Hello,
The **Arun Conservation Area Advisory Panel** wish the following comments to be taken into consideration in the determination of the applications:

LU/234/25/PL - 5 Selborne Place, Selborne Road, Littlehampton
Objection

PROPOSED GROUND FLOOR PLAN. 1:100

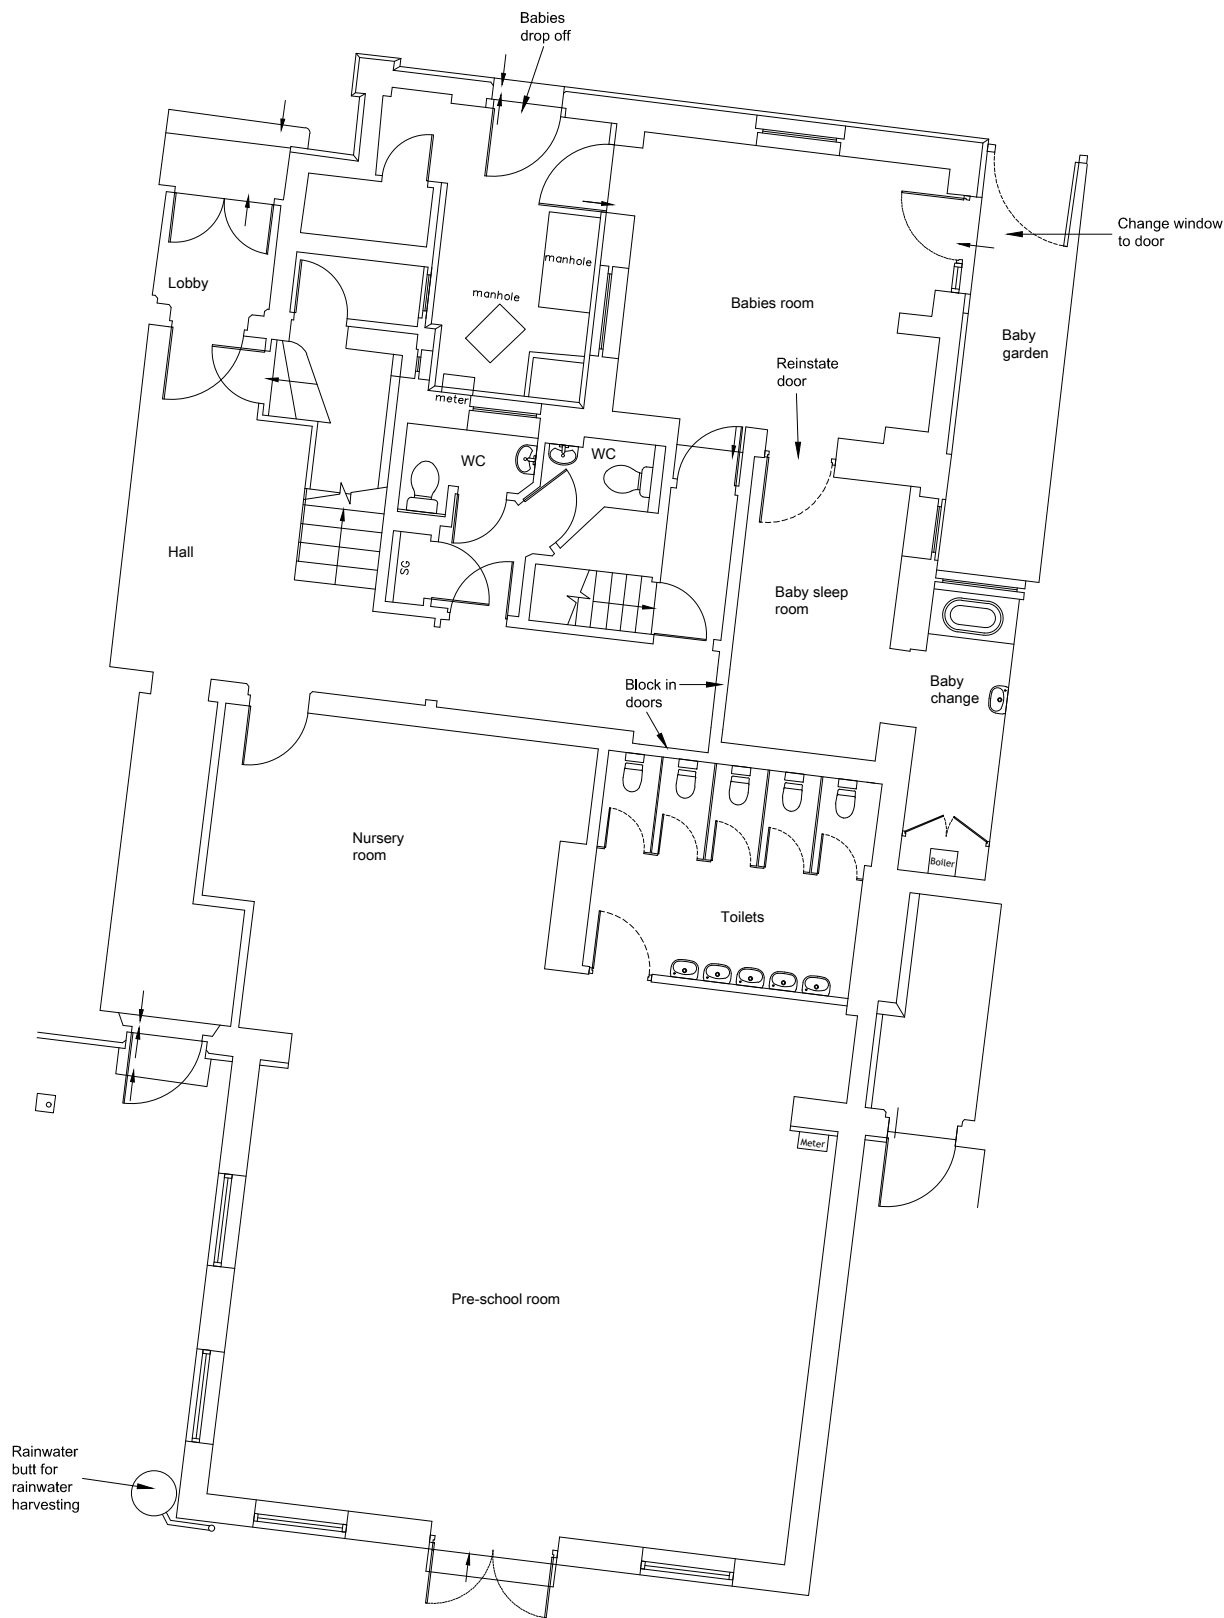
The proposed extension, which is basically a flat roofed box in form, will obliterate an important hood moulded Gothic Revival double arched window and door, and also the lower part of what is currently an attractive two storey angled bay window. It has to be questionable whether any form of extension could be accommodated successfully in this particular location.

In conclusion, is considered that the proposal by reason of its scale, form, design and siting will materially detract from the host building, and its important architectural features. As such, the proposal will also detract from the character and appearance of the conservation area and will conflict with the relevant paragraphs of the NPPF and policies contained in the ADLP relating to the protection of designated and non-designated heritage assets.
